RE – Yass Valley Wind Farm Preferred Project Report response (our ref. 4743)

ISSUES AND APPROACH OVERVIEW

TITLE
 EA & PPR
 Turbine Layout
 Comparison

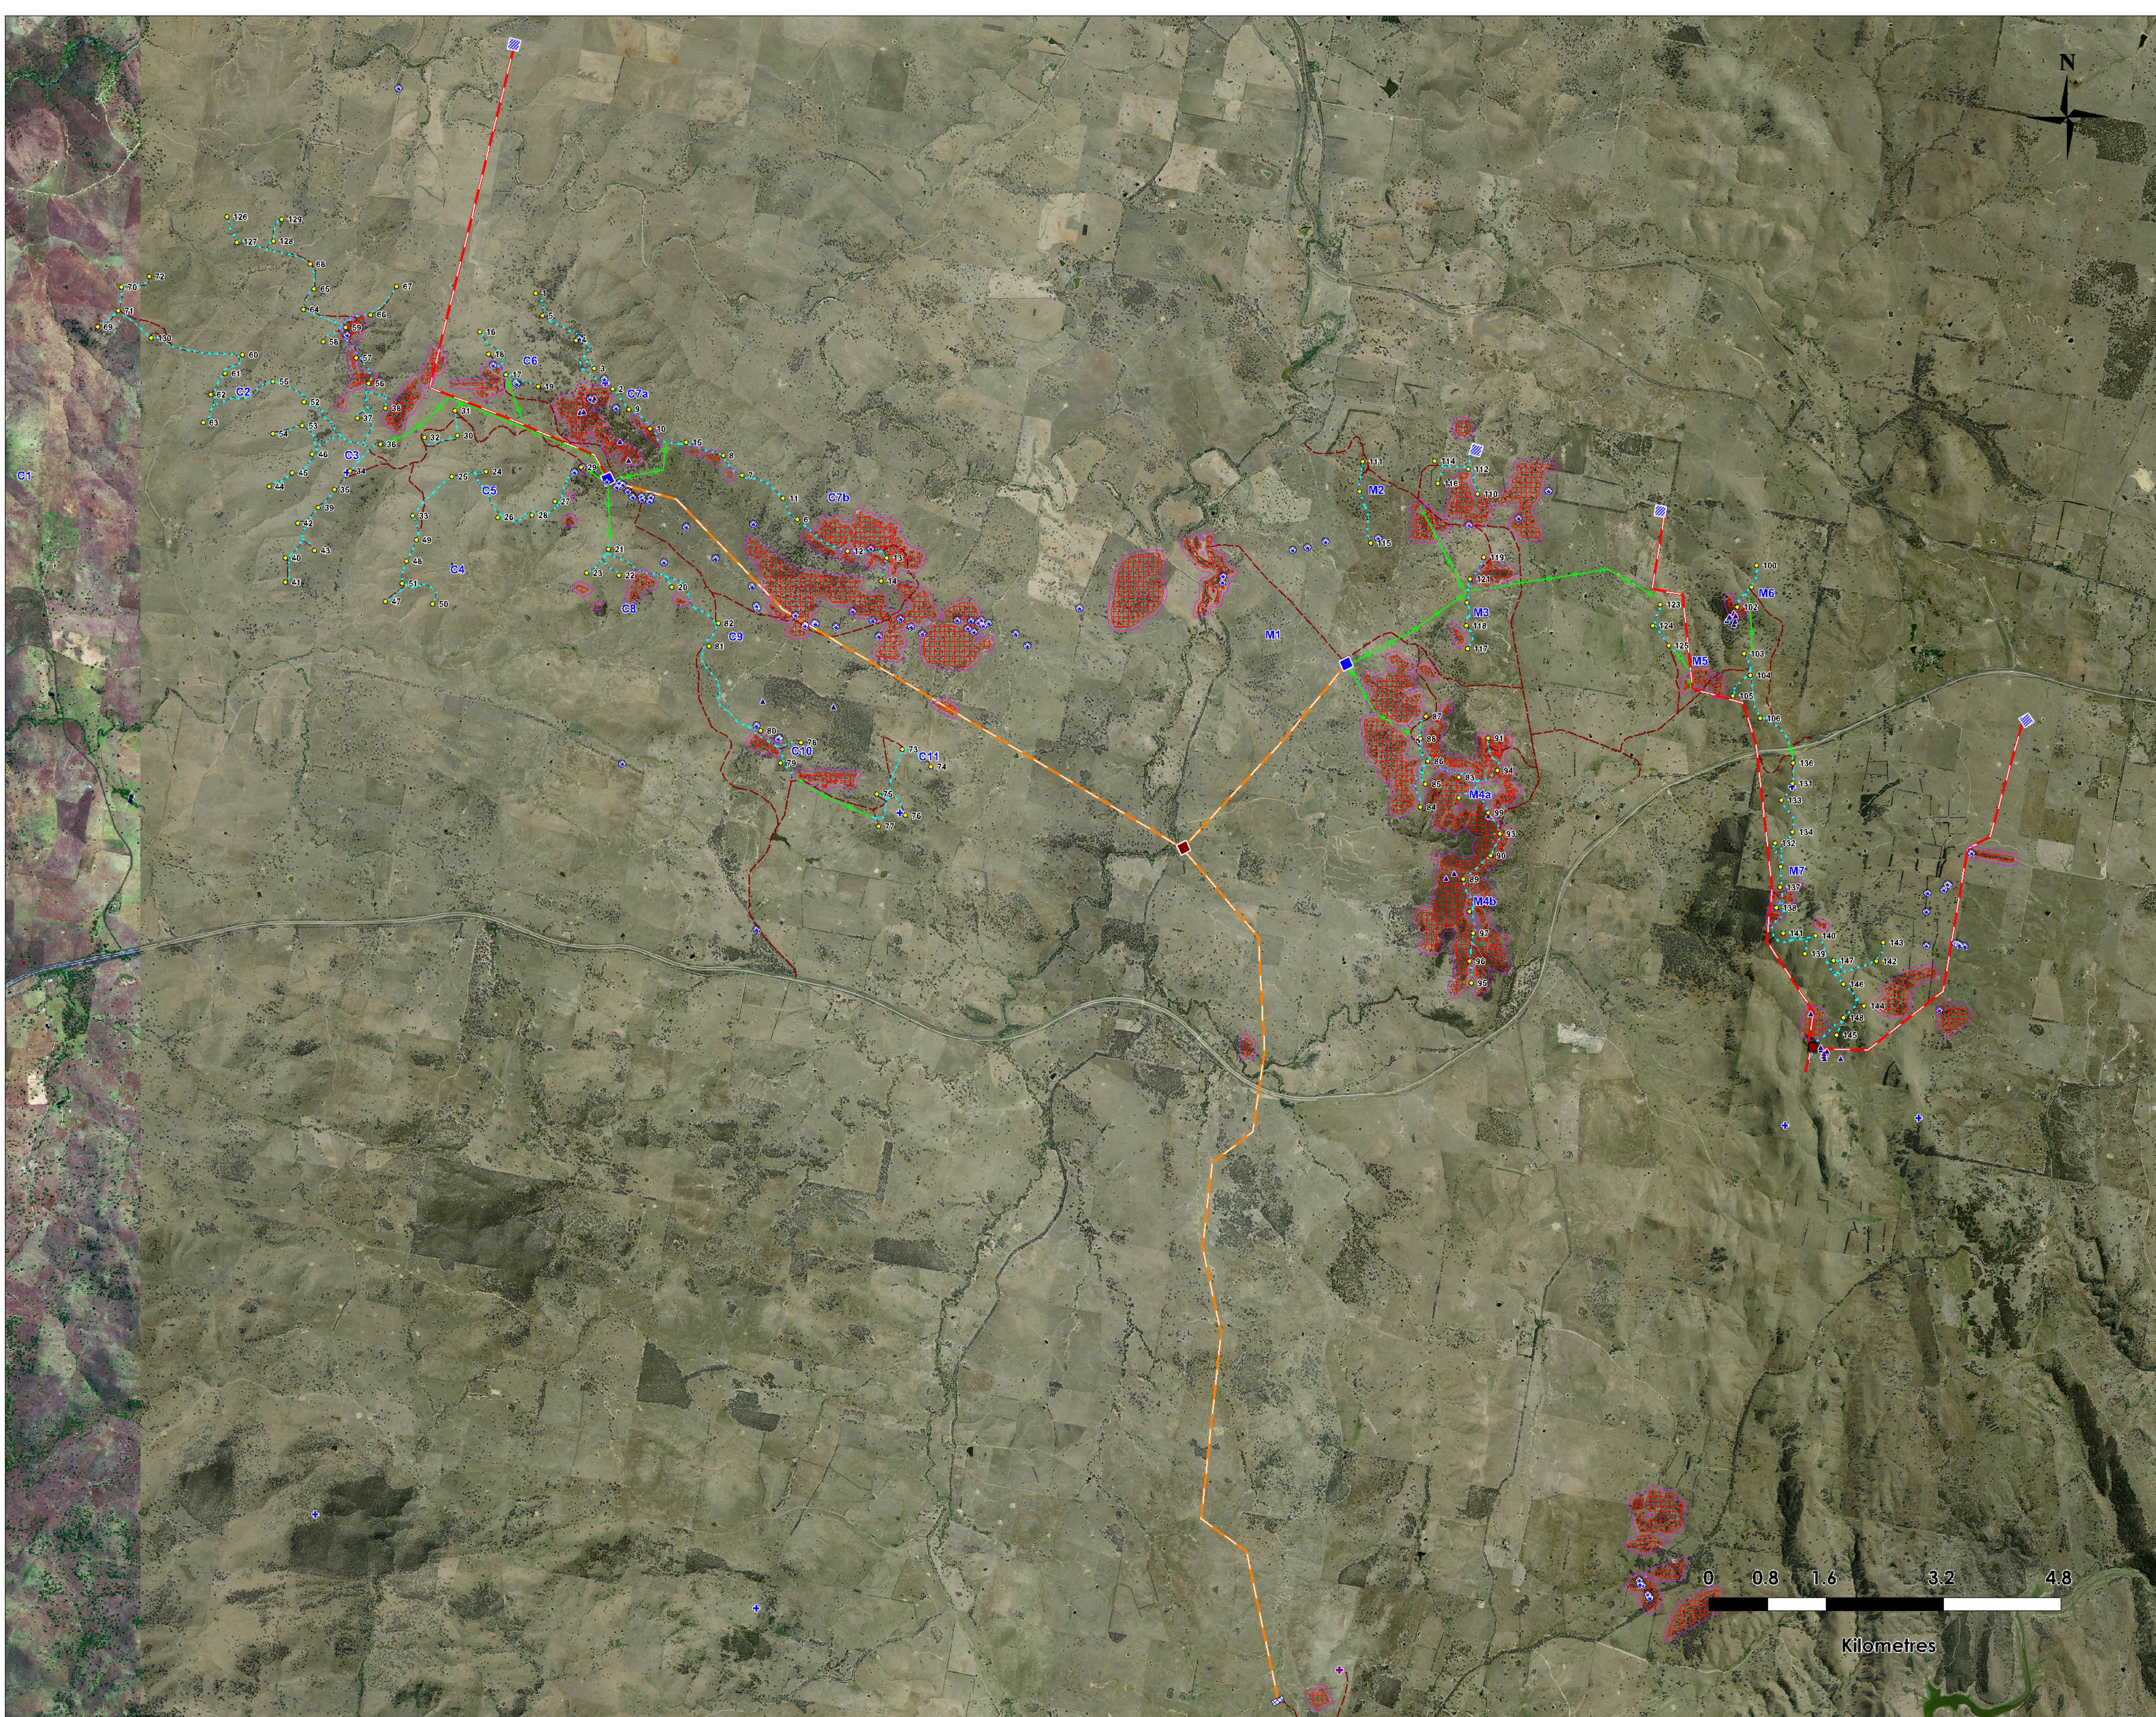
OEH issue	Comment / clarification	Suggested timing and approach
	<p>Where uncertainty exists with regard to impacts, and as a further opportunity to minimise impacts, we regularly recommend that micro-siting be undertaken with input from an ecologist. Examples in this proposal include, to minimise impacts on better quality areas of Box Gum Woodland EEC. This allows a response based on the specific survey findings. Specific protocols would be detailed within the BMP. Reporting and auditing, to ensure all conditions of consent have been met, are also part of the draft standard conditions for wind farms.</p>	
New positions or turbines relative to constraints	<p>OEH require a map showing the new positions or turbines relative to the areas mapped as high constraint in the original EA, to understand how the changes to the layout have reduced biodiversity impacts.</p>	<p>Pre approval New map provided.</p>

1. Layout comparison EA vs PPR layout, showing changes in turbine layout since the publically exhibited EA.
2. Vegetation types Updated vegetation mapping to show ‘worst case’ clearing estimate of EEC vegetation:
 - Areas of ‘pasture’ and ‘exotic’ vegetation have been moved in to Box Gum Woodland in poor-moderate condition, as a precautionary treatment, in advance of detailed field validation.
 - EEC in ‘moderate to good biometric condition’ has been outlined.

TITLE
Biodiversity
High constraint areas

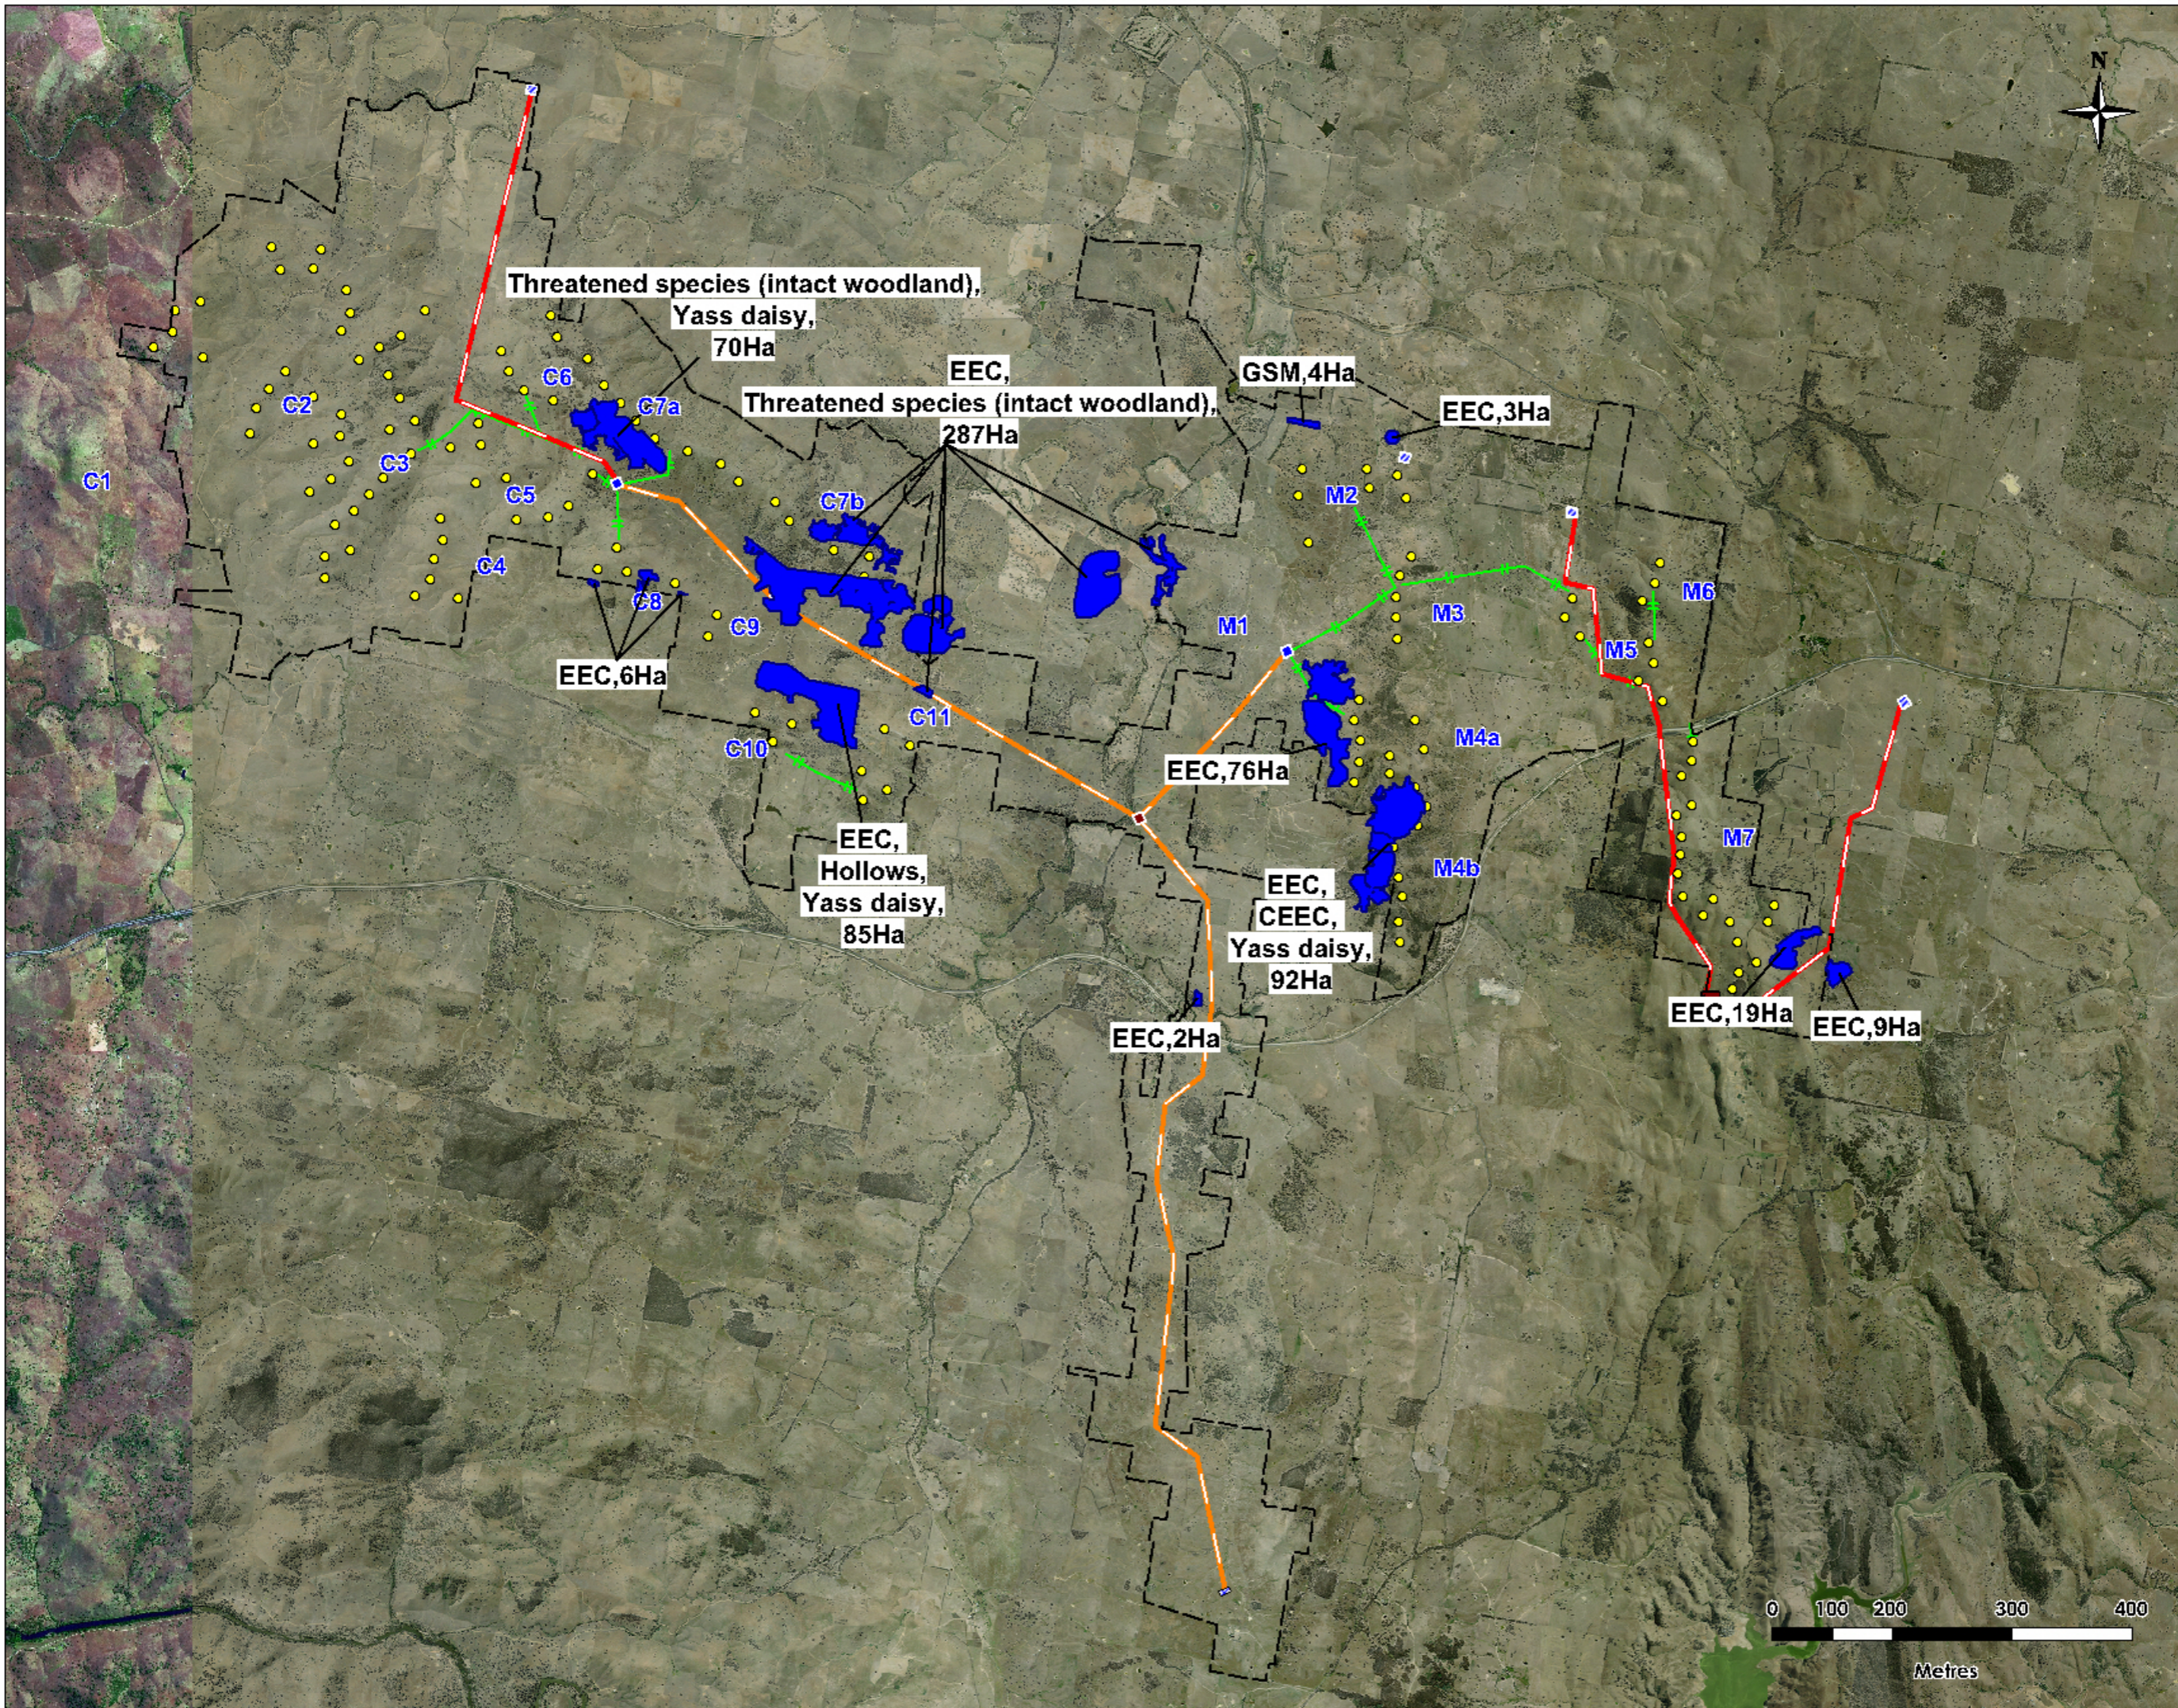
Turbine locations:	<p>OEH have nominated a number of turbines they do not support, close to woody vegetation and ridges.</p> <p>It is noted that while all high constraints areas mapped by ngenvironmental have been avoided by turbines, some associated infrastructure falls within these areas (tracks and powerlines). It is proposed that these areas be shown on the constraints mapping such that minimal road widths only are allowed in these areas.</p> <p>It is noted that OEH have stipulated several turbines they do not support that are located outside of constraints areas. These turbines cannot be moved further from the mapped constraints. It is proposed that OEH's input into the constraints mapping will ensure a clear map set accompanies the development proposal. After consideration of the additional information provided in this letter and gleaned from the site inspection, we invite OEH to identify additional high constraints areas to be included in this map layer. If any further site inspections are required by OEH, Epuron will facilitate this.</p>	<p>Pre approval</p> <p>A constraints layer will be developed with input from OEH to ensure all areas not endorsed by OEH are included.</p> <p>If this requires any additional site inspections by OEH, Epuron would facilitate this.</p>

OEH issue	Comment / clarification	Suggested timing and approach
	<p>OEH require clarification on where infrastructure would be located, relative to high conservation value grassland where the Yass Daisy population is located and an increased buffer on Yass Daisy individuals.</p> <p>A map showing the locations, habitat and proposed infrastructure has been provided with this response. The constraints mapping provided now shows these areas as high constraints to be avoided.</p> <p>It is acknowledged that, while all identified populations have been avoided, that all areas of potential Yass Daisy habitat have not been avoided. It is proposed that, by avoiding known populations and managing impacts in these areas, that indirect impacts can be adequately managed sufficient that the local occurrence of this species will not be adversely impacted by the development of the wind farm.</p> <p>Specific commitments of the PPR include:</p> <p><i>Works should be sited outside known Yass Daisy population areas and Commonwealth-listed CEEC areas identified in Appendix 3.1 Coppabella Hills Precinct Biodiversity Assessment (Figure 5.6), Appendix 3.2 Marilba Hills Precinct Biodiversity Assessment (Map set 2) and the SER (Error! Reference source not found.) .</i></p> <p><i>[Note: this includes the proposed cable route at site 35].</i></p> <p><i>The proposed cable route would be located to avoid direct or indirect impacts to all recorded plants and colonies, with a minimum 2 metre buffer [NOW UPDATED TO 5M IN THIS RESPONSE]. The Yass Daisy population would be identified and protected during the construction and operation phases. Special rehabilitation measures would be used for works in the vicinity of the population, including topsoil removal, storage and replacement, whole sod removal and replacement if practicable and effective weed control at all stages. Exposed areas along the trench line would be revegetated with local native grasses (<i>Microlaena stipoides</i> and/or <i>Themeda triandra</i>).</i></p> <p><i>If works are proposed outside of the targeted survey area within the area of occupancy for the Yass Daisy mapped in nghenvironmental (2009c),</i></p>

3. High constraint High constraints from the BAs and SER are mapped. This includes:
 - WF site (BAs):
 - EEC in ‘moderate, moderate to good and good’ condition

It is noted that the impact of turbines within high constraint areas is not the same as tracks or transmission infrastructure. Some fine scale mapping has been undertaken to allow minimum width tracks in high constraint areas. In these areas, minimising impact on overstorey vegetation can be seen to have been achieved. Where transmission lines occur in high constraint areas, pole footings can be placed either side of the high constraint boundary or in a way that avoids tree clearance.
4. Potential offset sites Potential offset areas include connected mature woodland, EEC and threatened species habitat.
